DRB Application No.: 07DRB-00341 (SBP)

Project Name: LADERA BUSINESS PARK
UNIT 2

DEVELOPMENT REVIEW BOARD – SPEED MEMO

To: billy@goodwinengineers.com
Subject: Ladera Business Park , Unit 2 Site plan

**STREET TREE REQUIREMENTS**

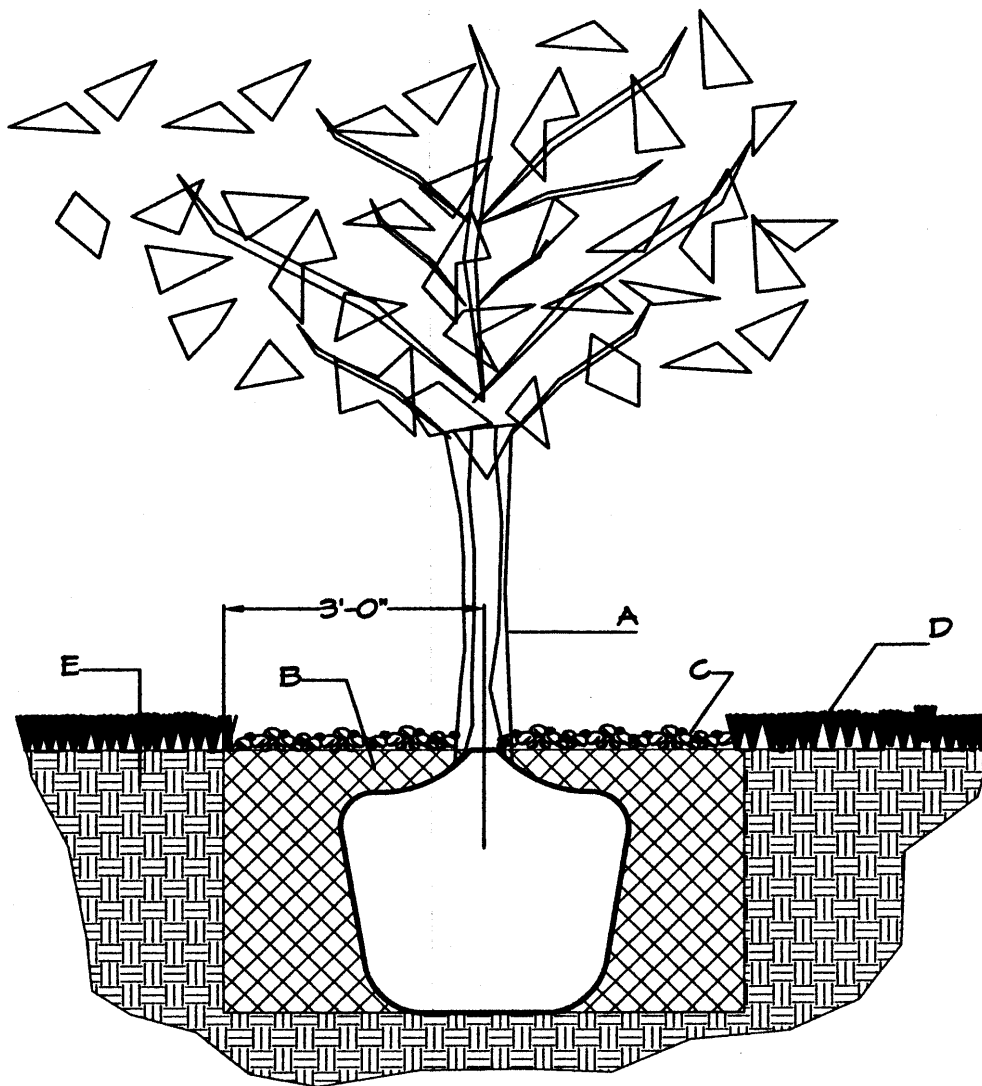
I looked at the latest submittal of the site plan. Unfortunately, I'm not sure anything was fixed except the addition of the easements on the landscape plan. The Landscape Plan is now a larger scale & half upside down. Plus I can't find the 17 street trees along the street as indicated.

PLAT FOR
TRACTS 20-A, AND 20-B
LADERA BUSINESS PARK, UNIT 2
 WITHIN THE
 TOWN OF ATRISCO GRANT
 PROJECTED SECTIONS 9 AND 10
 TOWNSHIP 10 NORTH, RANGE 2 EAST, NMPM
 CITY OF ALBUQUERQUE
 BERNALILLO COUNTY, NEW MEXICO
 May, 2007

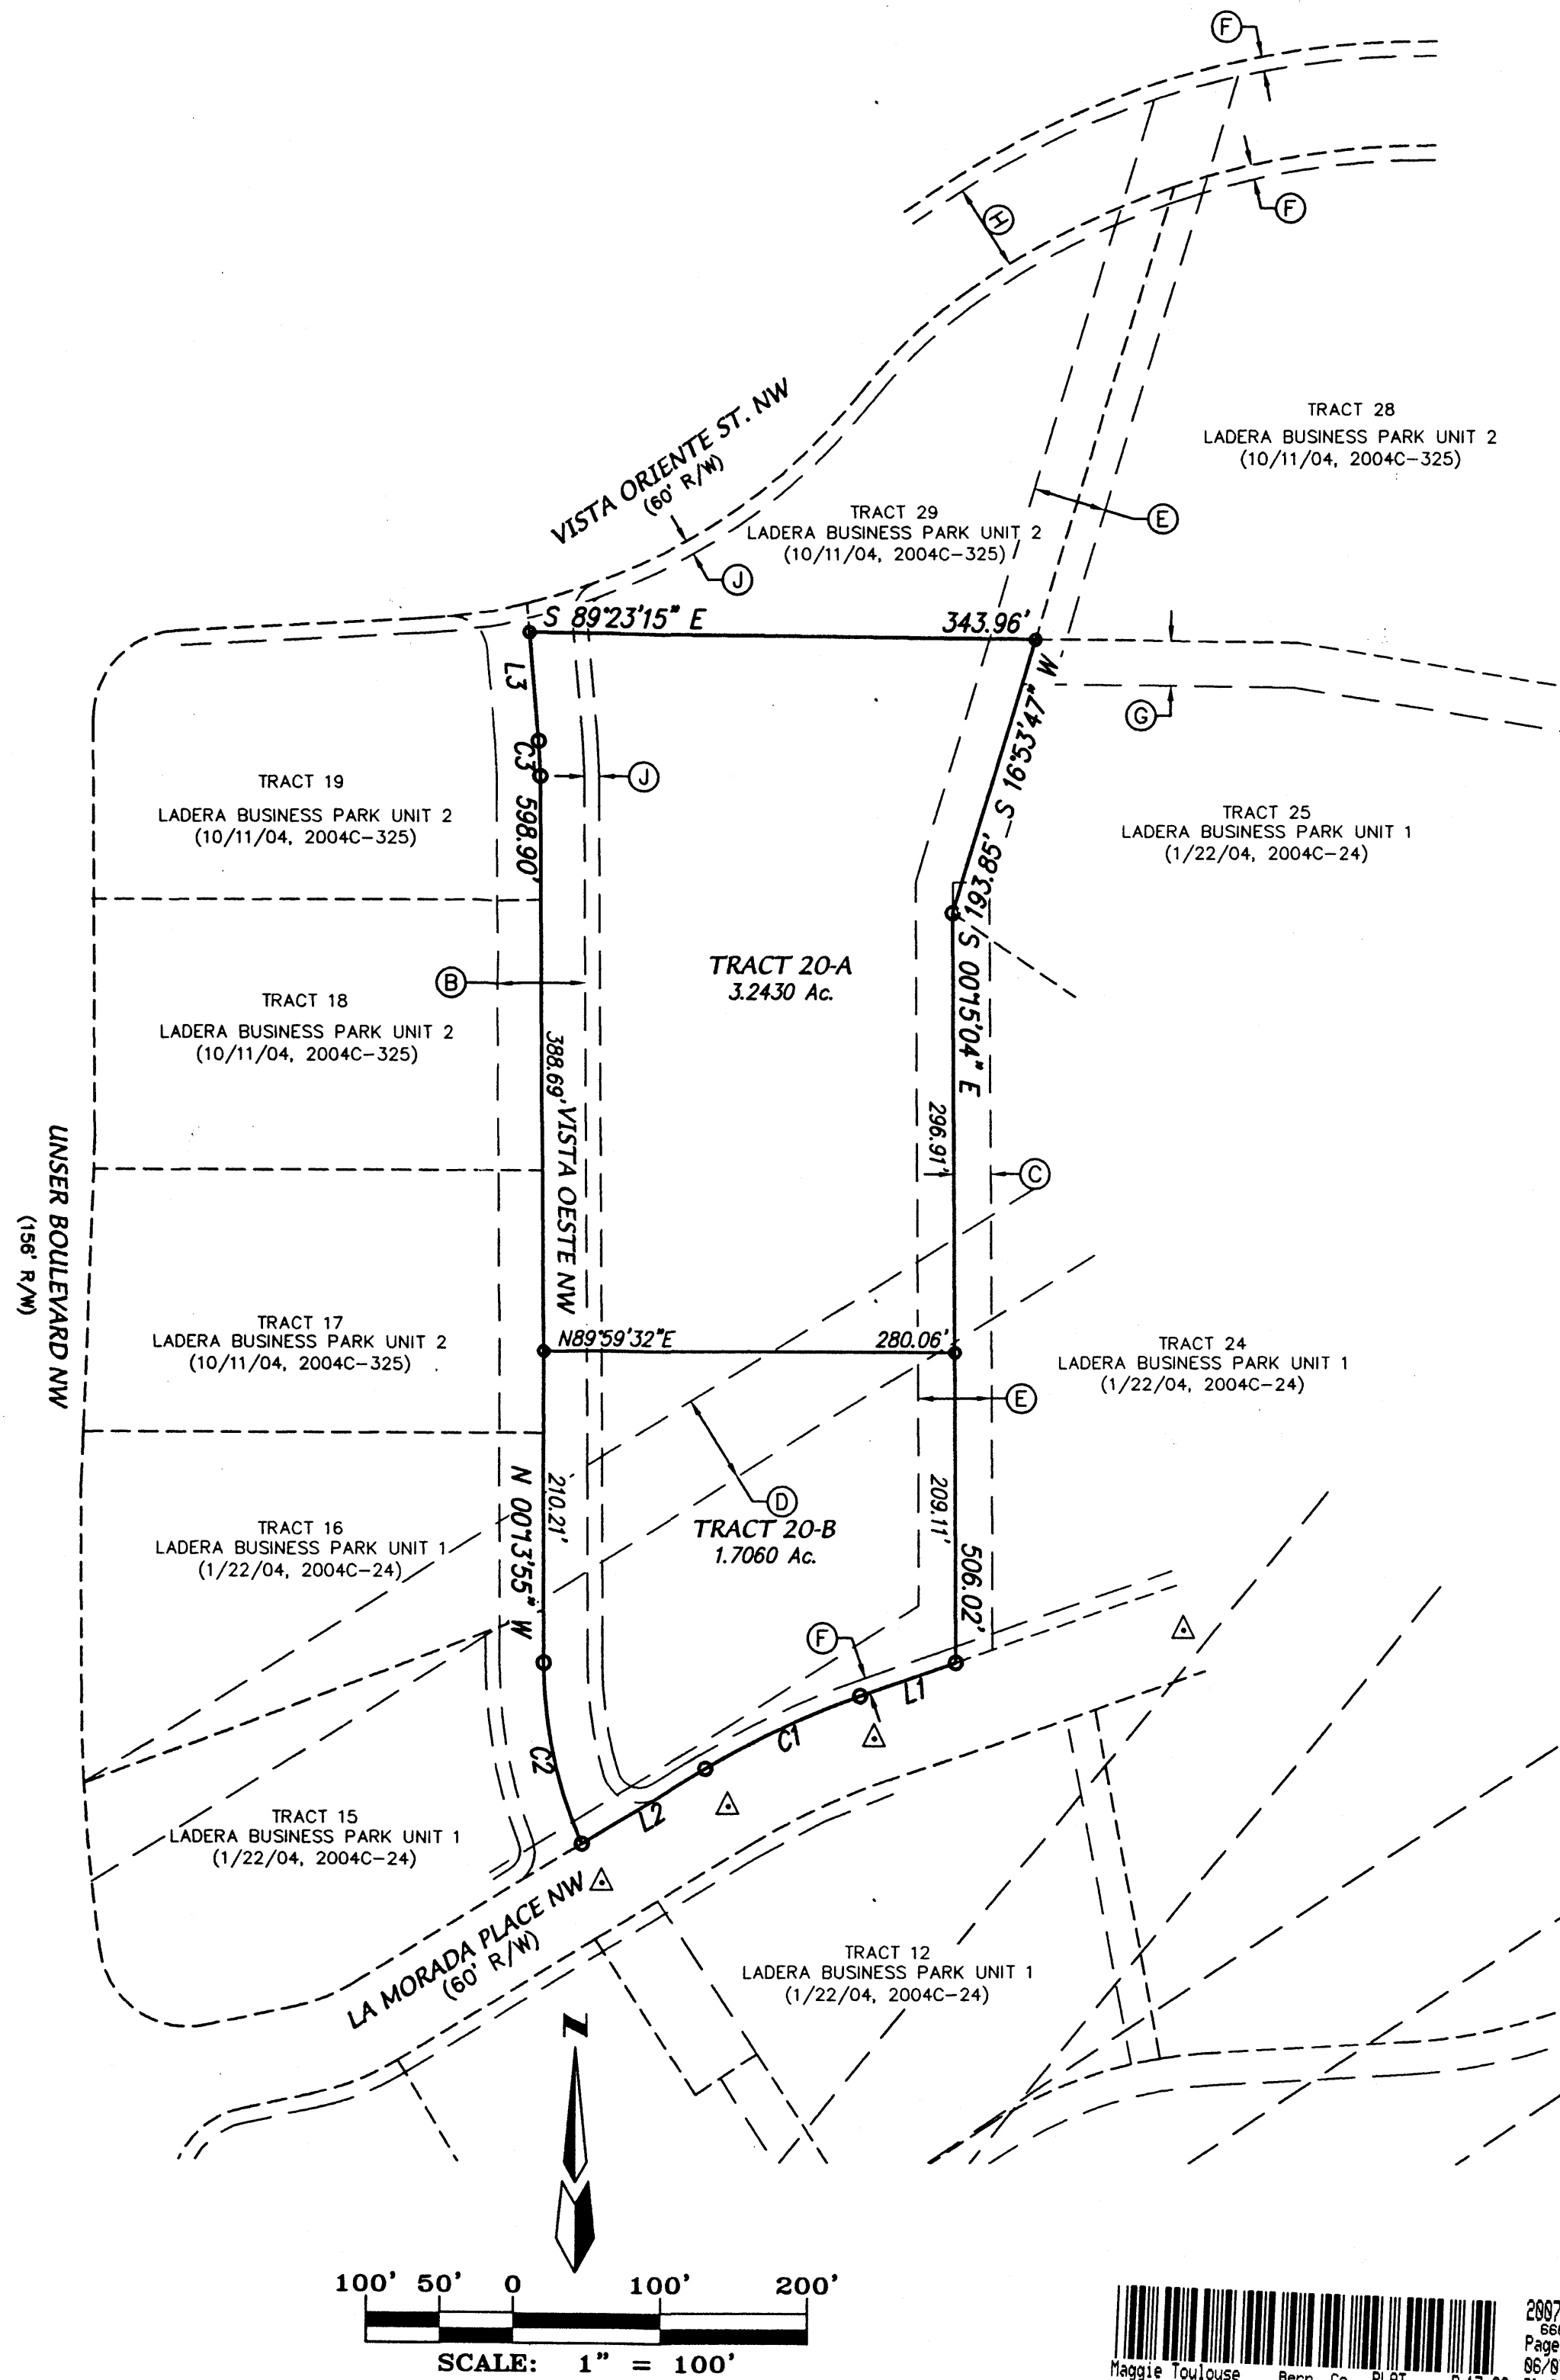
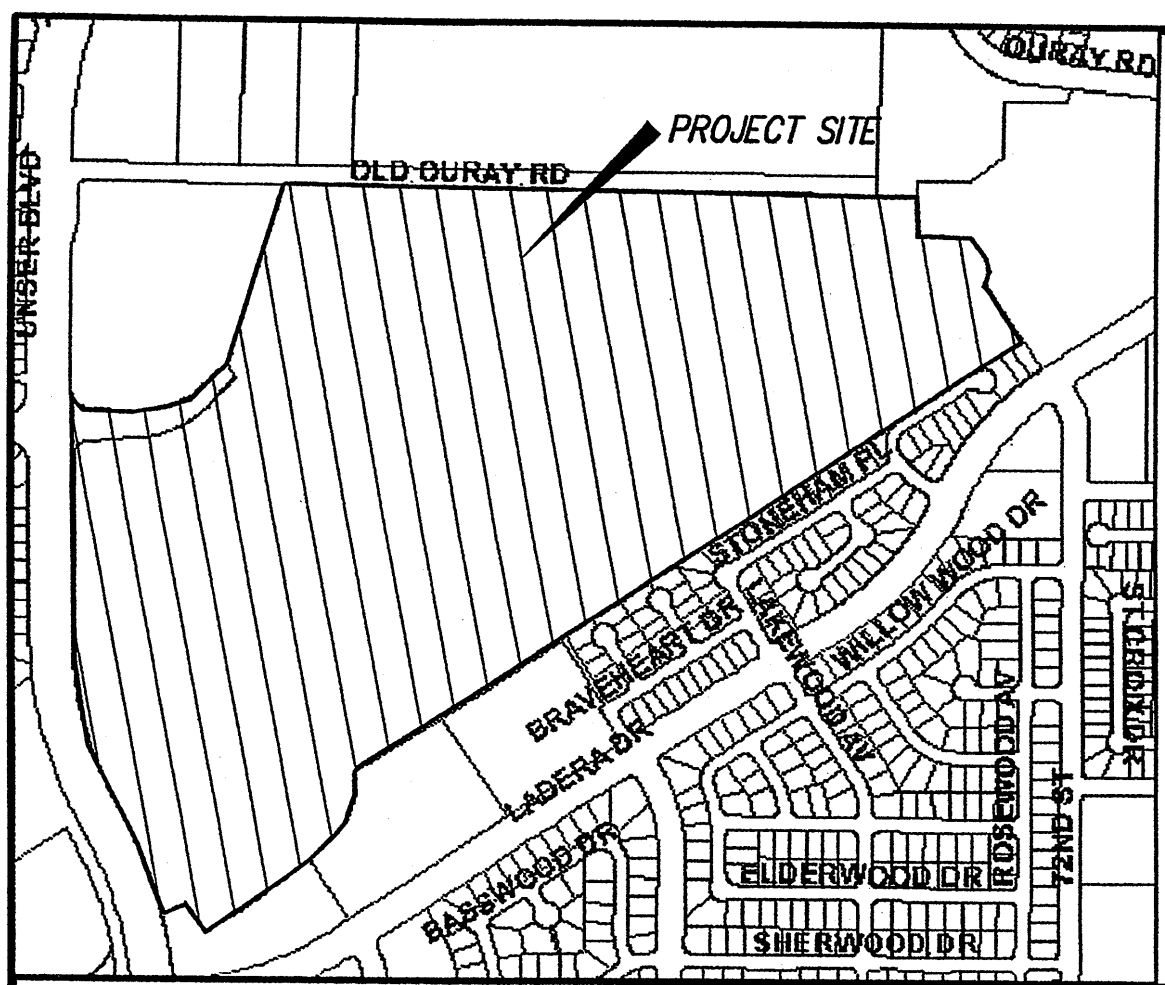
TRANSPORTATION: Cross access easement

LADERA BUSINESS PARK
CONCEPTUAL UTILITY PLAN

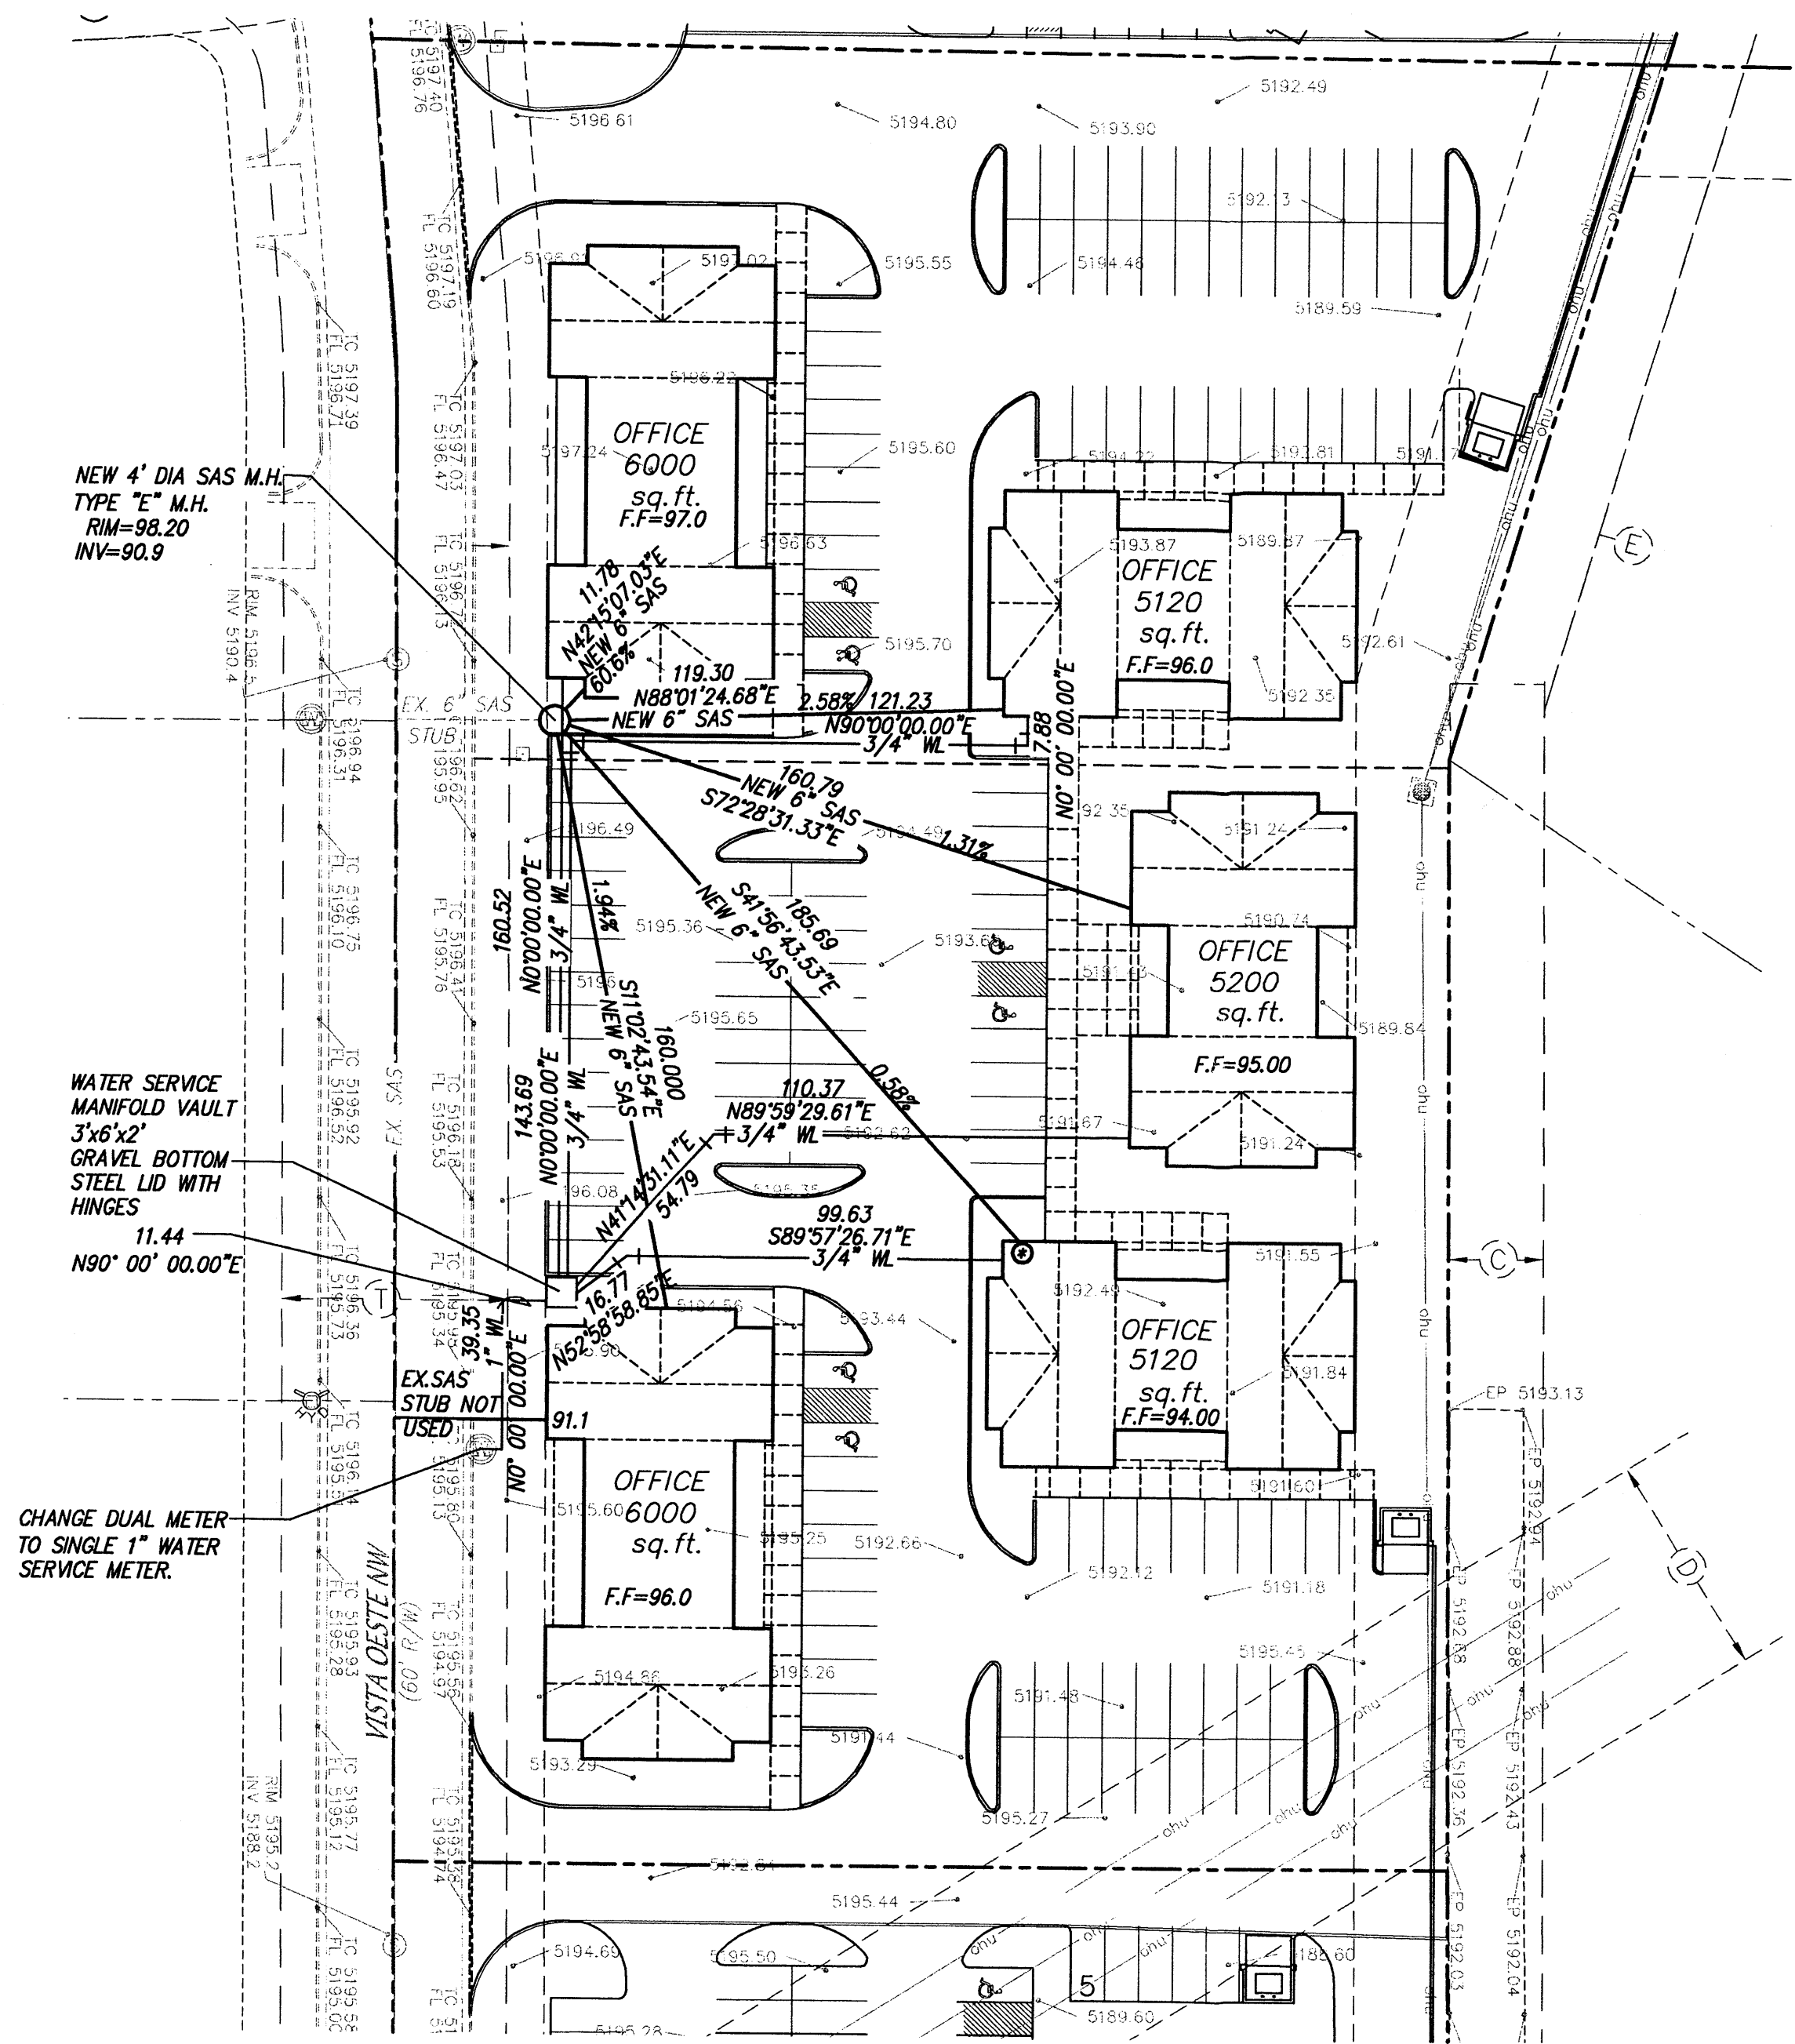
UTILITIES: revised utility plan
